Application No: FG/19/21/PL
Site Address: First Floor Flat 60 Ferring Street Ferring BN12 5JP
Description of works: Change of use of flat above restaurant to a bar. This site is in CIL Zone 4 (Zero Rated) as other development.

OWPC34524

TITLE	PROPOSED FIRST FLOOR PLAN & PARTY WALL TREATMENT DETAIL
-------	--

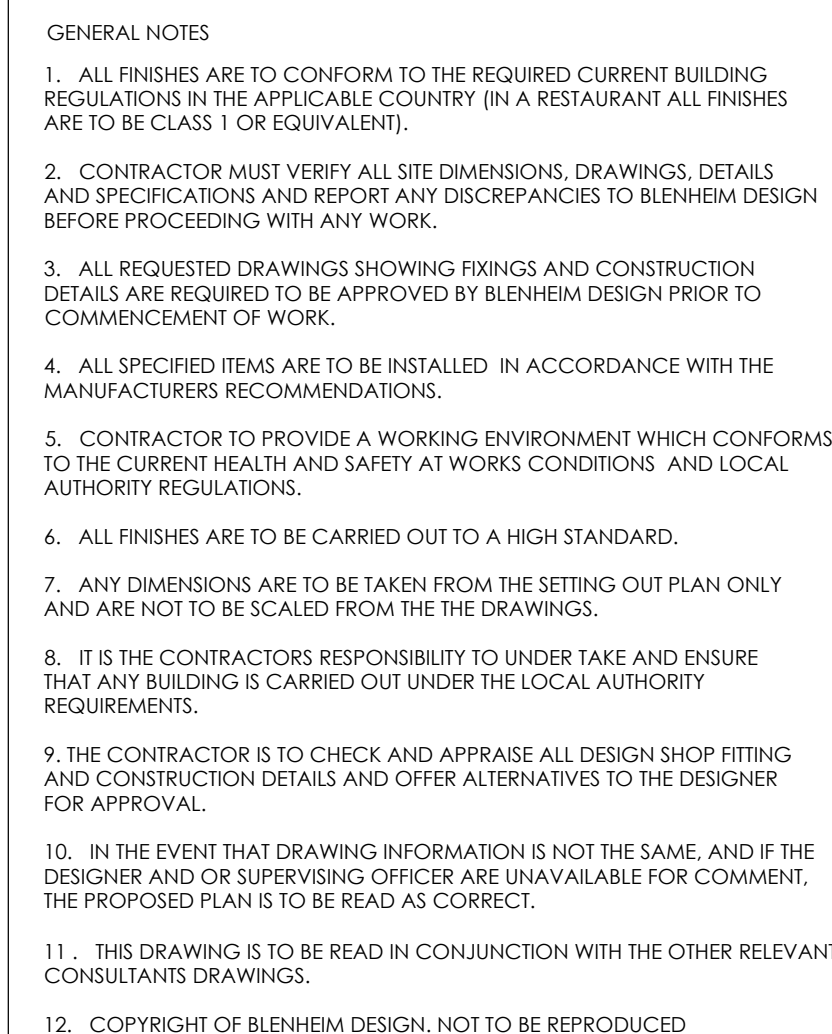
- the suitability of the emergency exits from the first floor in a commercial environment.
- noise impact on neighbours, notwithstanding the proposed acoustic treatment to the party wall.
- potential access to the first floor outdoor 'patio' area which would have serious disturbance consequences for neighbouring residents. This is not indicated as a public area on the plans but should ADC be minded to approve this application, restrictions to this area should be made conditional.
